DRB CASE ACTION LOG - BLUE SHEET

Project #: 1009158 Application #: 12DRB-70059  
 Project Name: Franciscan Addition  
 Agent: Aldrich Land Surveying Phone #:

**Re: Franciscan Addition, Block 14, Tract 23-A-1 – Lot Consolidation Plat**

Drawn By:	JPA/TA	Date:	05-24-11
Checked By:	TA	Drawing Name:	10049PLT.DWG
Job No.:	10-049	Sheet:	2 of 2

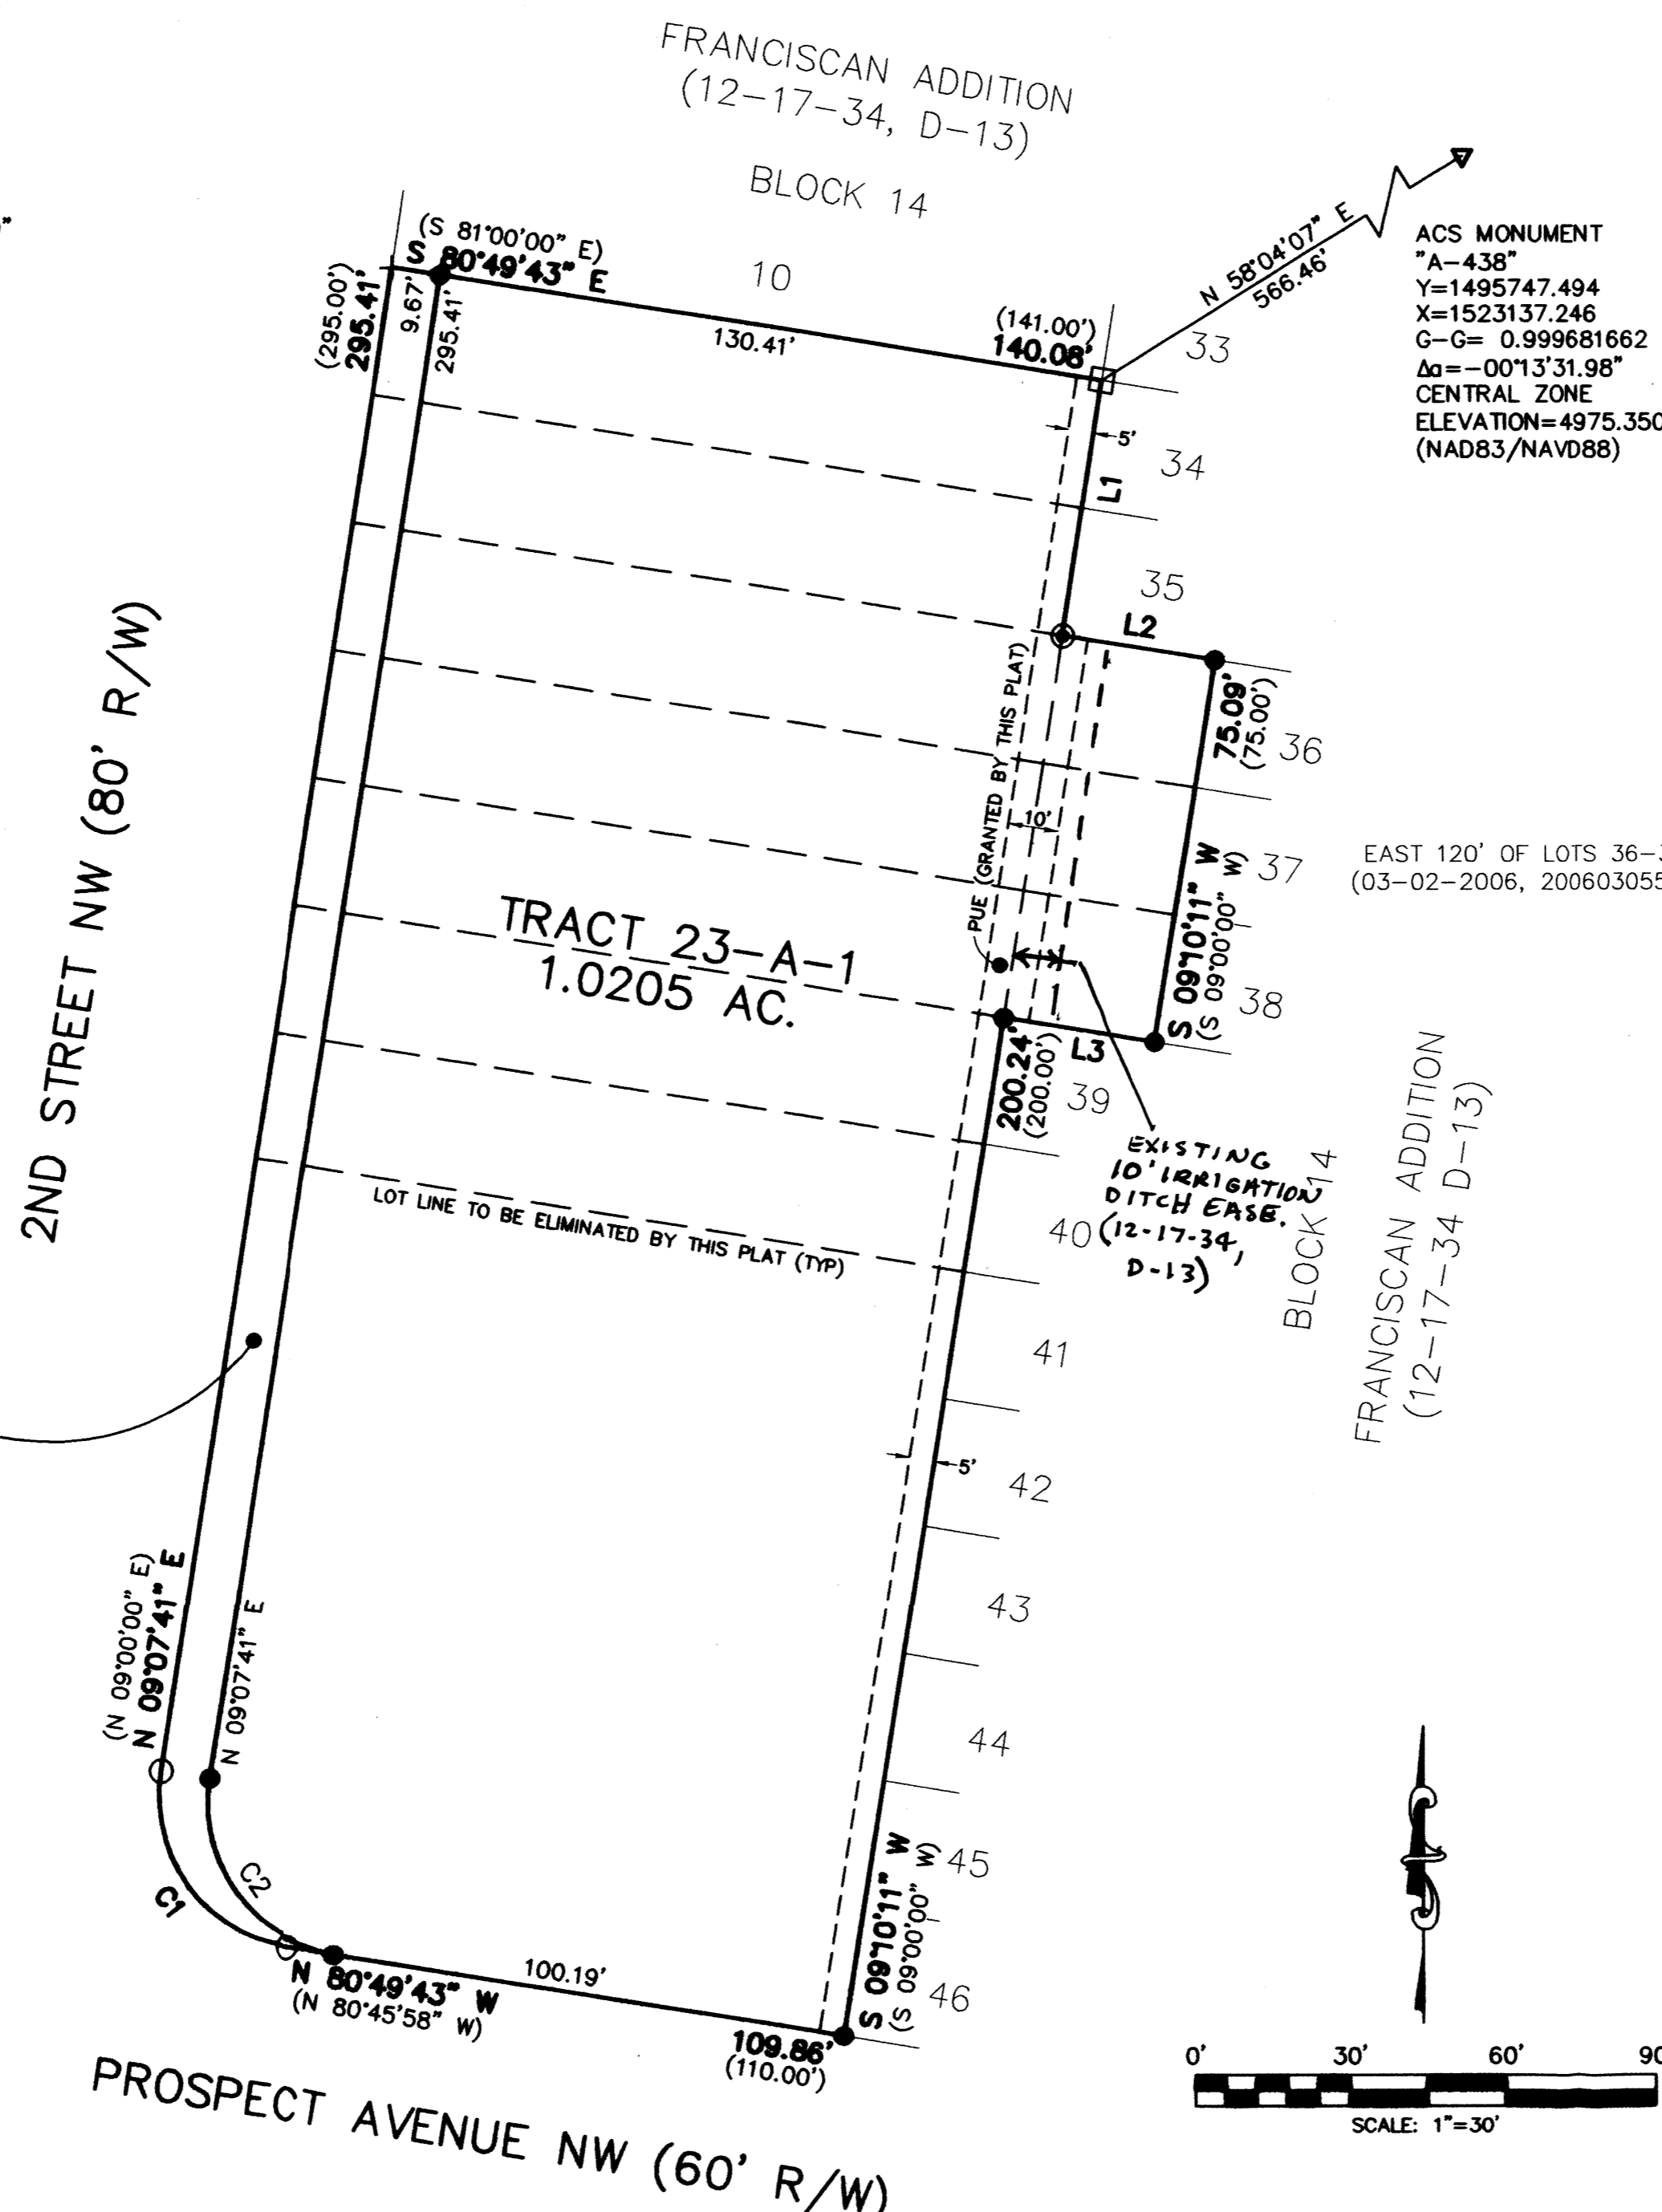
TRANSPORTATION: exhibit showing curb / R-O-W

PLANNING (Last to sign): verify "portions of" prior to 1973
